APPENDIX A - TABLE OUTLINING ISSUES WITH REVISED CONCEPT DEVELOPMENT PROPOSAL No. SSD8707 – WITH RESPECT TO REVISED RESPONSE TO SUBMISSION (RTS) dated November 2019

Ivanhoe Estate Masterplan Macquarie Park, NSW Masterplan Envelope Control Plan

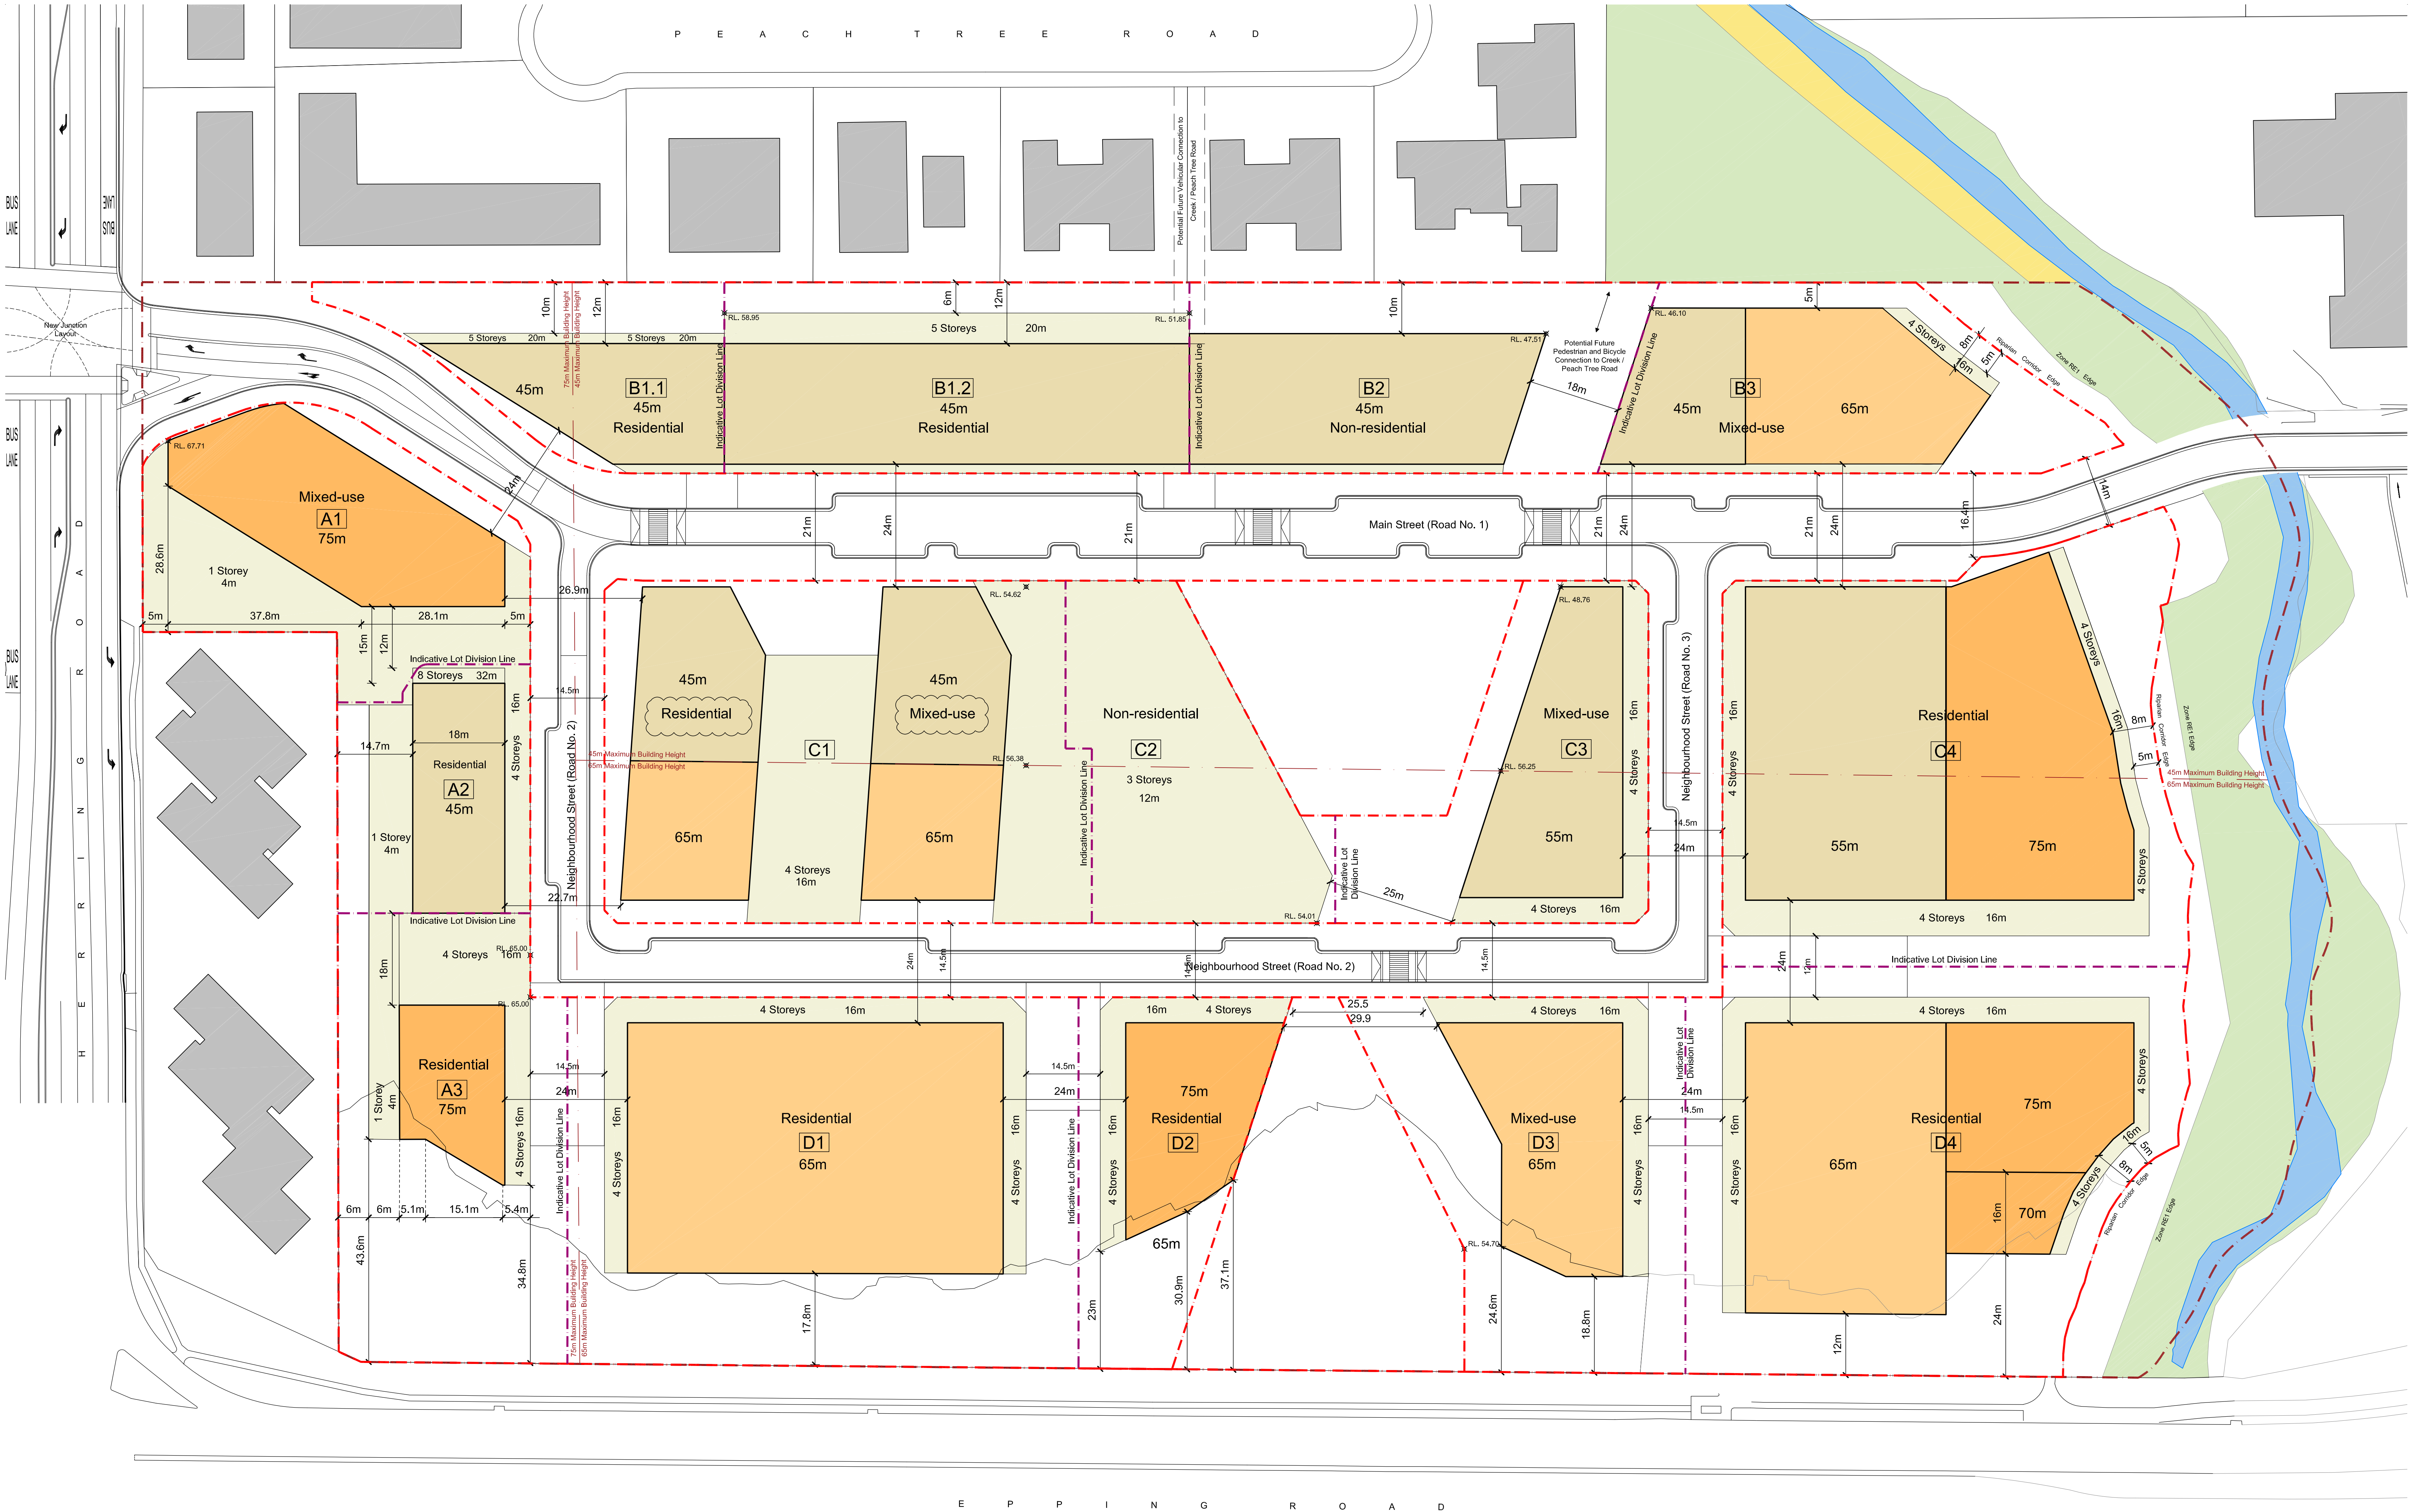
| # | ISSUES PREVIOUSLY RAISED By COUNCIL | REVISED RESPONSE TO SUBMISISON AS EXIBITED: NOV 2019 | CITY OF RYDE's POSITION ON THE ISSUES AFTER REVIEW OF THE NOVEMBER 2019 AMENDMENTS |
|----|--|--|--|
| 12 | <p>Height of building</p> <p>Initial proposal was fully compliant with maximum height restriction under the RLEP 2014</p> | <p>Building height has been re-distributed across the site resulting in non-compliance with height of certain buildings.</p> | <p>Council notes that the development does not comply with the building height restrictions. Council acknowledges that the redistribution of height results in an improvement in the amenity in the Village Green and solar access to apartments within the site.</p> <p>It is noted that the height of a number of buildings are over the maximum.</p> |

Shared Boundary with 137-143 Herring Road - 2018/2019 Development Plan Changes

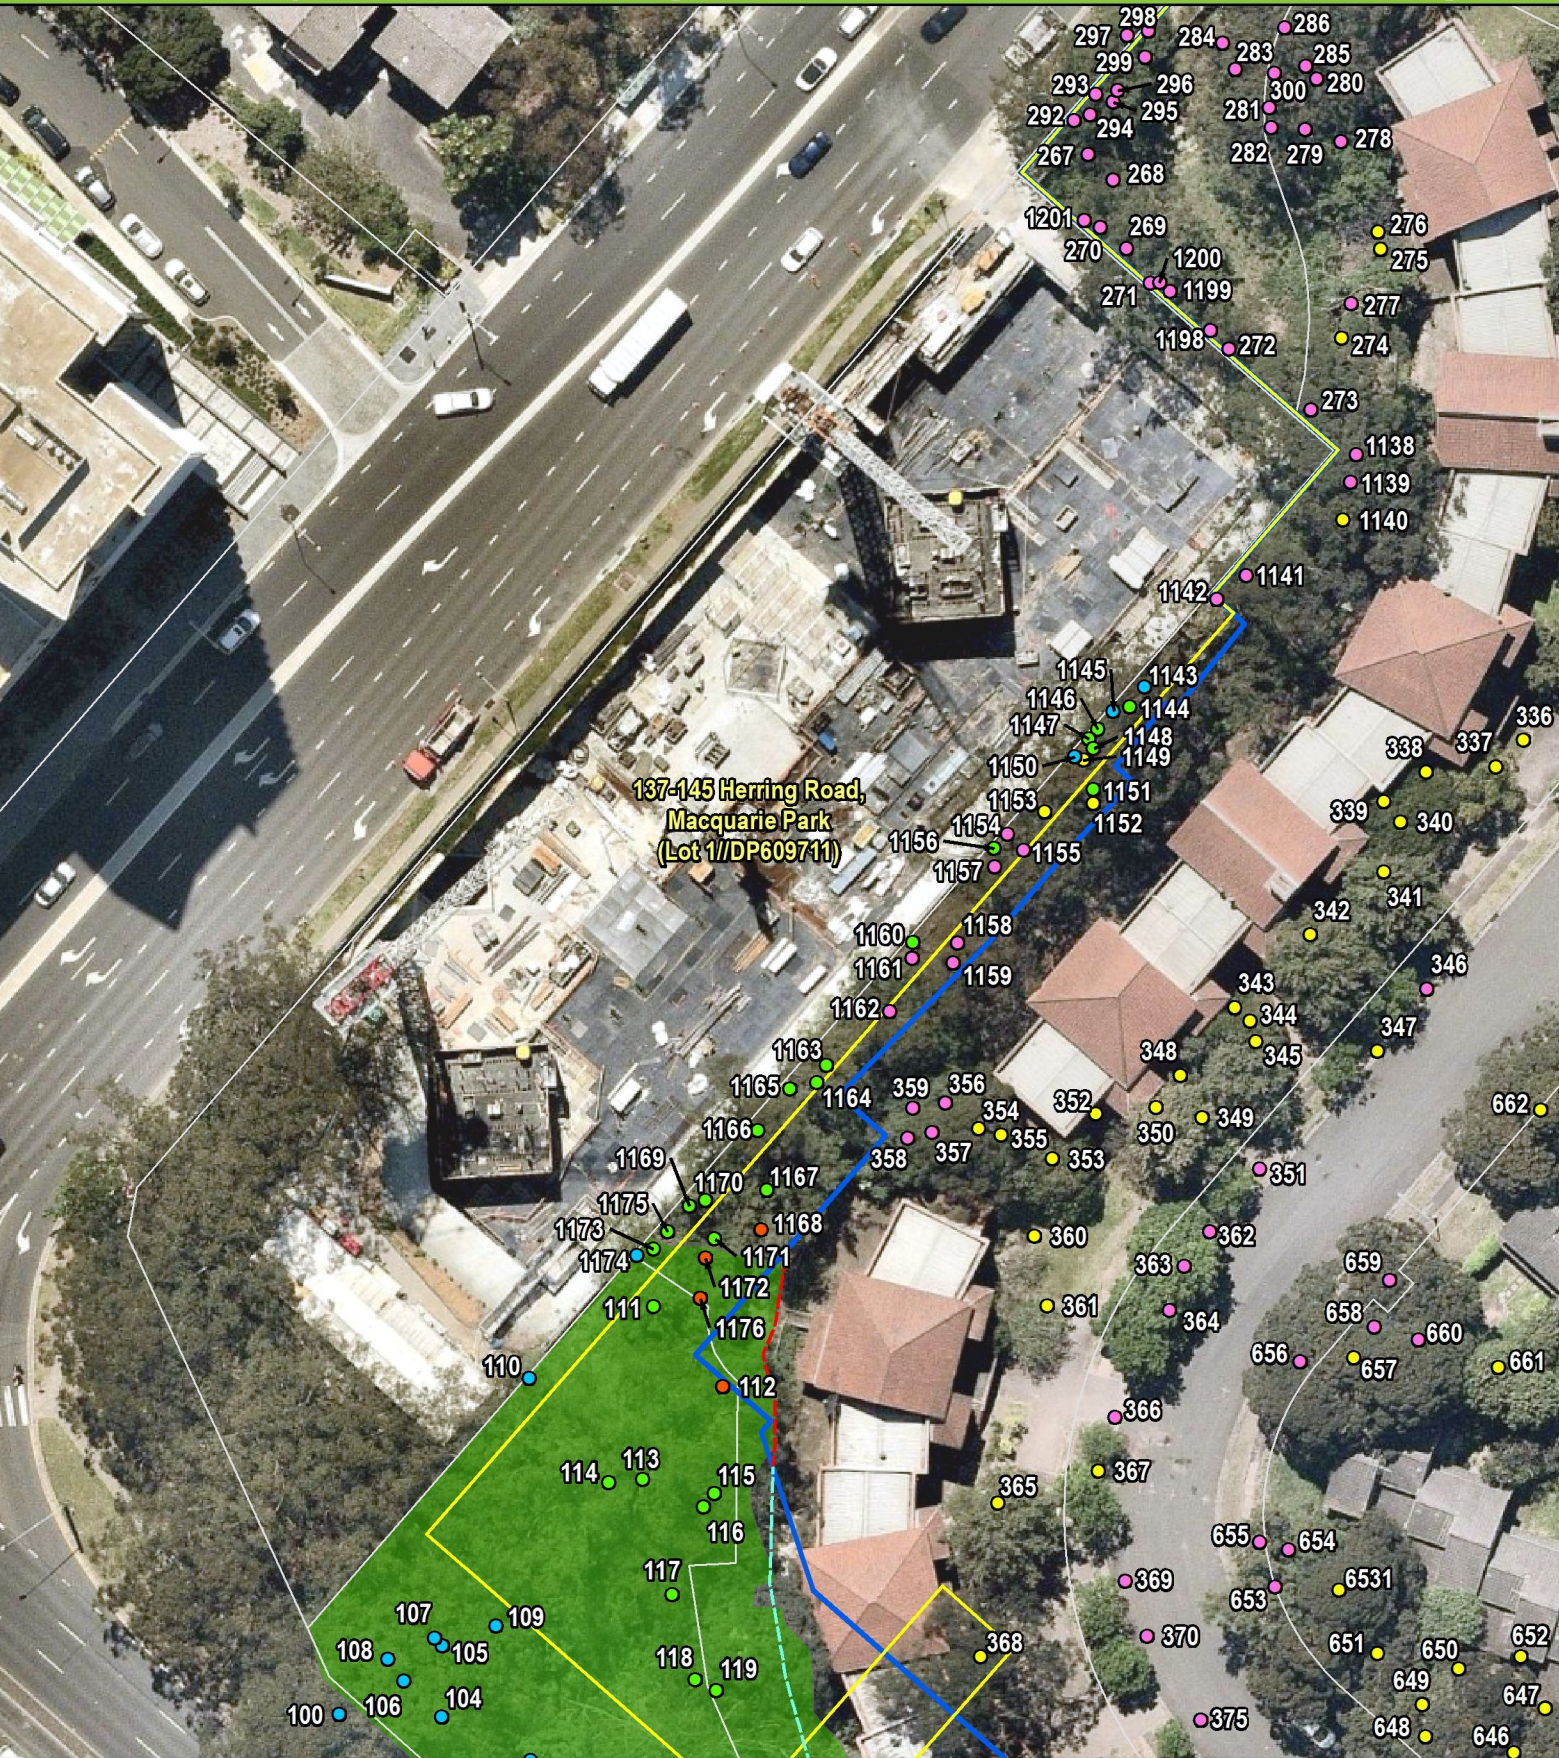
| # | ISSUES PREVIOUSLY RAISED By COUNCIL | REVISED RESPONSE TO SUBMISISON AS EXIBITED: NOV 2019 | CITY OF RYDE's POSITION ON THE ISSUES AFTER REVIEW OF THE NOVEMBER 2019 AMENDMENTS |
|---|---|---|---|
| 4 | <p>Building Setbacks</p> <p>Lack of regard for the adjoining approved building at 137-143 Herring Rd</p> <p>Nov 2019 Plan</p>  | <p>A setback of zero to 6m is proposed adjacent to the side and rear boundaries of No. 137-143 Herring Road.</p> <p>The revised response does not provide any further information or justification other than <i>"the one storey element of Building A2 and A3 has been set back 6 metres from 137-143 Herring Road"</i> and completely ignores the '0' setback for Building A1.</p> <p>A zero setback and any setback less than 10m is inadequate. The 6m setback to the rest of the building (A2 & A3) are not adequate to retain the contiguous vegetation along the boundary that links to the EEC. Especially the trees adjacent to Building A3 are important as it provides the visual link and buffer.</p> <p>In fact the revised plan is made worse off compared to the first scheme where the setback was 10m instead of 6m.</p> <p>The design, setbacks, envelopes on the subject site should establish a positive relationship with adjoining sites and environmental features. However, City of Ryde is still concerned that the basement, podium and ground floor level are still proposed to the boundary for most of the buildings (refer to Building A1, A2 & A3).</p>  <p>Original Concept Plan 2018 (10m setback)</p> | <p>The basement to the north west boundary has been set back '0' to 6 metres. The setbacks along north western side of the site are still unsatisfactory in that Building A1 basement and ground level is proposed on the boundary of 137-143 Herring Road site. Further the original setback of 10m along rest of the boundary has been reduced to 6m. This new setback needs to be assessed by the Arborist to determine what trees can be retained or to be removed.</p> <p>Council contends that trees need to be retained and additional deep soil areas need to be provided around the boundaries to allow for medium to large native trees to be planted. These deep soil areas need to be wider than 6m to enable retention of existing trees and allow future trees to grow. A 12m setback is required for adequate building separation to comply with the Apartment Design Guide. The Arborists Report does not provide any assessment of whether any trees would be retained along this side of the site.</p> <p>The 6m setback to the rest of the building (A2 & A3) are not adequate to retain the contiguous vegetation along the boundary that links to the EEC. Especially the trees adjacent to Building A3 are important as it provides the visual link and buffer.</p> <p>City of Ryde seeks the following:</p> <ol style="list-style-type: none"> The setback be increased to 12m throughout along the northwestern side boundary and adjacent to 13-143 Herring Road. This new setback needs to be assessed by the Arborist to determine what trees can be retained or to be removed.  <p>Revised November 2019 Plan (Compare setback – made worse)</p> |
